Our ref: HA/2017/119308/03-L01
Your ref: PAC/SLTSDN/00199
Date: 24 October 2017

DOCUMENT REVIEW - SITE INVESTIGATION

DEVELOPMENT AT KINGS CLOSE, YAPTON LAND AT KINGS CLOSE, YAPTON, BN18 0EX

TITLE: Exploratory Hole Location Plan

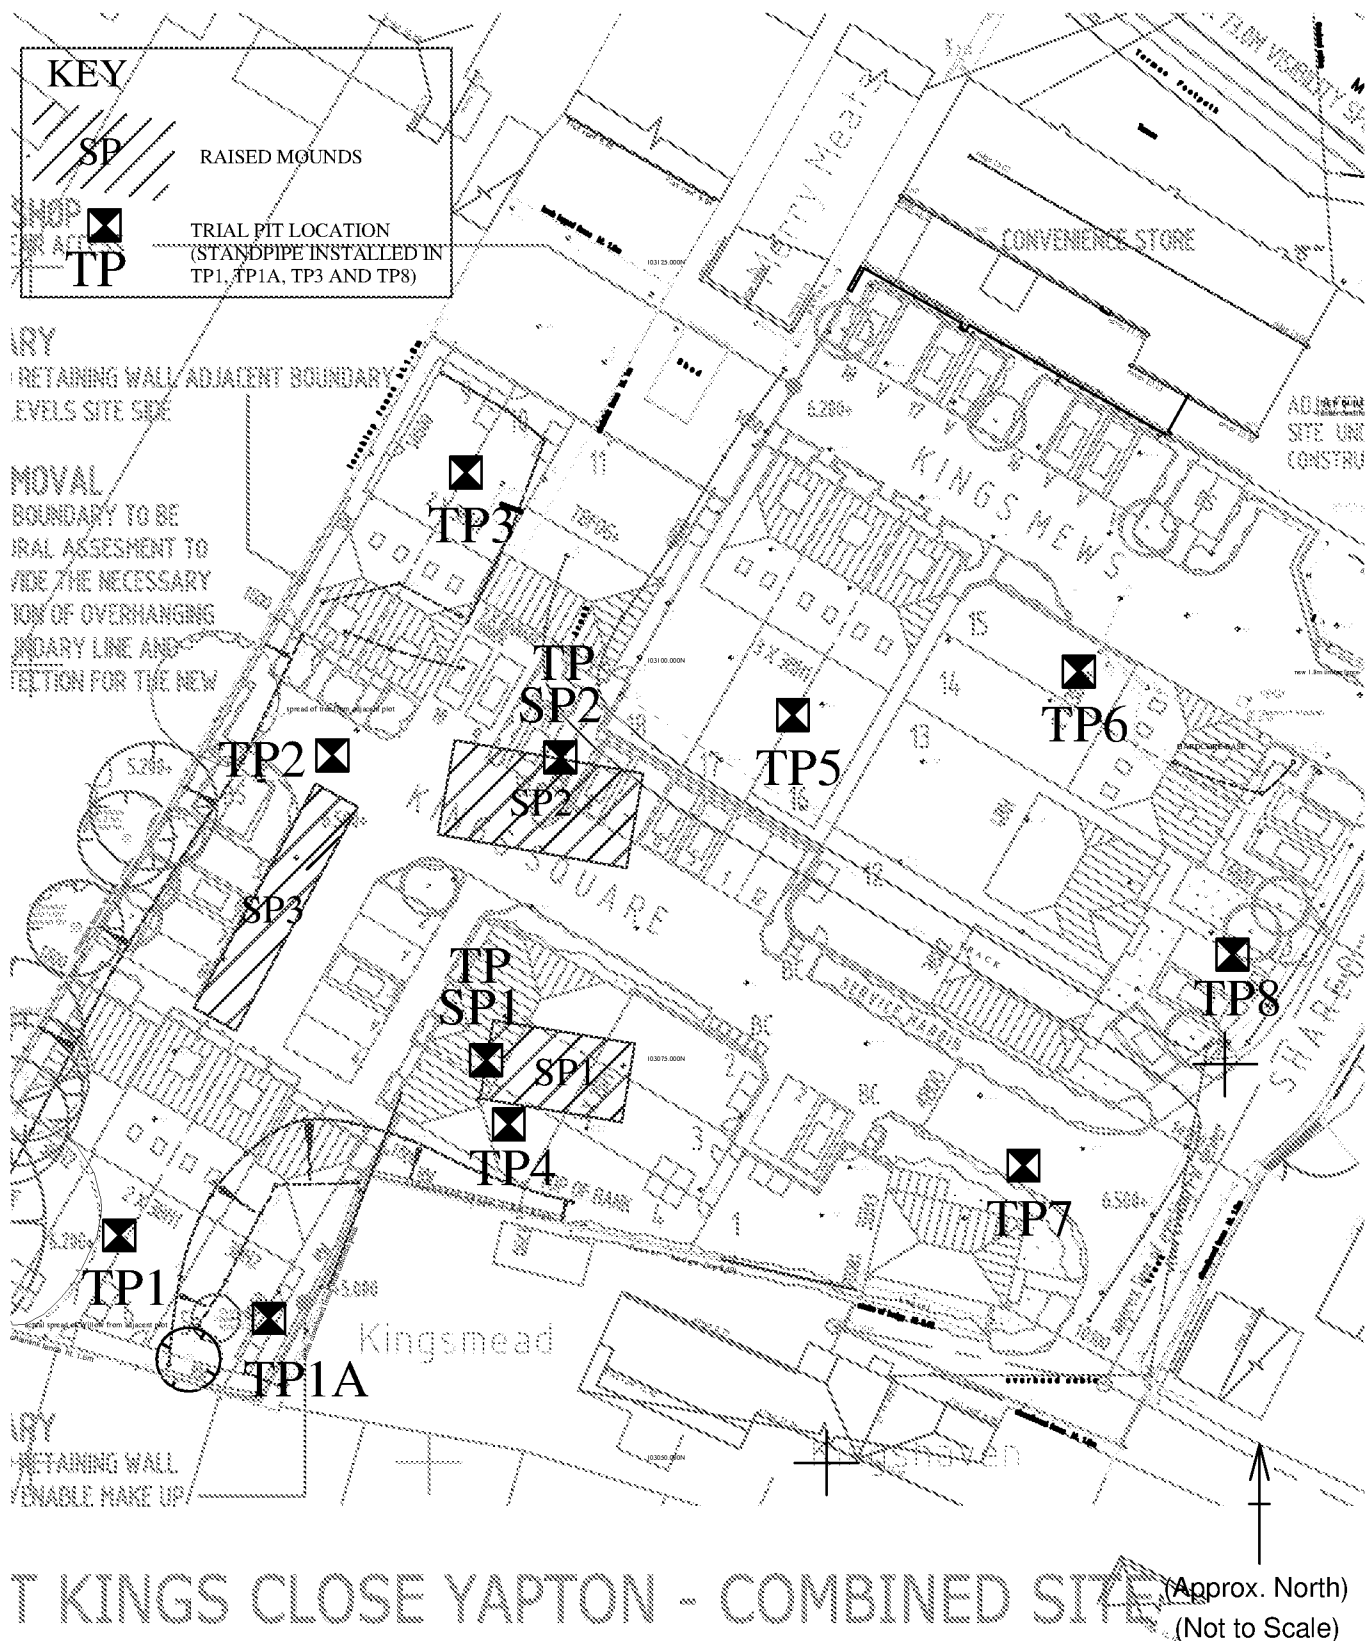
We have reviewed the latest report produced by Ground Management Ltd. The report provides further information on additional investigations that have been undertaken in key areas where previous soil and groundwater contamination was identified. The investigations from the window sampling holes have identified further contamination, particularly around TP8 and WS4.

We agree that the results from BH1 do not present a significant risk of wider groundwater pollution from the site.

We agree that potentially the contamination around TP8 and WS4 is a result of a historic spill of potential source and support the requirement for further investigation during site strip and development. We also agree that any material identified as impacted visually or olfactory should be removed from site in these areas. and verification sampling undertaken.
